Address: 4 Reinwood Avenue Huddersfield hd34dp

Application number: 2023/91191	
What is the application for?:	Erection of single storey rear extension and alterations
Address of the site or building:	2, Reinwood Avenue, Quarmby, Huddersfield, HD3 4DP
Postcode:

Type of comment: A supporting comment	
Do you wish your comments to be published on the website anonymously?	No
Aesthetic design & functional amenity: As the adjoining property owners we support the proposed development owing to its sympathetic design, which is proportionate and in keeping with the original character of this pair of unique adjoining 'Arts and Crafts' era properties. We see that it adds valuable modern domestic amenity of a kitchen-diner. We support the owner in creating additional living space for their family. Provided the materials used are in keeping with existing finishes, as indicated, we do not object on aesthetic grounds. We do not object to the proposed height or roof line or window positions. Though we suggest the use of obscured rooflight glass to mitigate the privacy loss from our upstairs rear bedroom which will partially overlook the new dining space. Boundary line shared hedge: We have verbal a

Underground Extension
1 : 50

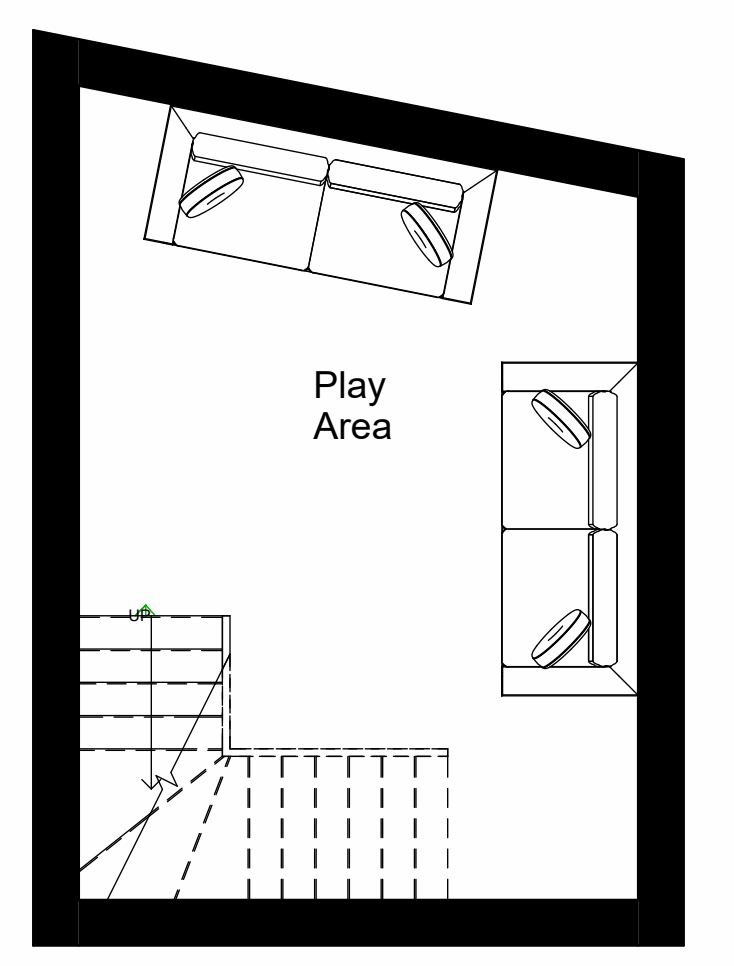
Excavation of a new subterranean basement, impact on party wall foundations and structural concerns:

Given the proximity of the development to our party wall (under 3 metres) and rear supporting walls, as per the owners' obligations under the Party Wall etc. Act 1996, we expect to receive a Party Wall Notice within the requisite period prior to work commencing.

We strongly encourage the owner to work with us ahead of issuing this notice to address our questions of the structural viability of their development (particularly re: new basement excavations and any adaptation of party wall footings that may be required). Prior to issuing a notice, we expect the owner to commission and share a structural surveyors' report, and share with us evidence of technical load calculations, scale drawings of the exact wall position near the boundary/footing and any resulting directives for the work. This may include further surveys e.g. water table or further details of dust and vibration minimisation measures. We expect close consultation and full visibility of any structural and foundation reports and consultations before a Party Wall Notice can be agreed to, or a Party Wall Agreement can be reached, and work can commence.

We understand the following matters are not the focus of the current planning decision but expect to be sighted and involved in the Buildings Regulations Process, particularly the officers assessment of excavation viability, foundations soundness, (esp. in relation to matters of the shared footings), load redistributions, clay ground substrate, tree roots, land grading and water table.

Of note: There is a historically diverted spring/stream that once ran close to the back of both houses in William Wood (a past owner said the gardens of no. 8 and 6 adjacent used to flood pre 1960's, which is uphill from both houses). Given this and the sloping grade and position of the proposed development we suggest a water table survey would be prudent, so as to mitigate the risk of creating any unintended water capture, heave or subsidence from poor drainage design around the 'tanked' basement.
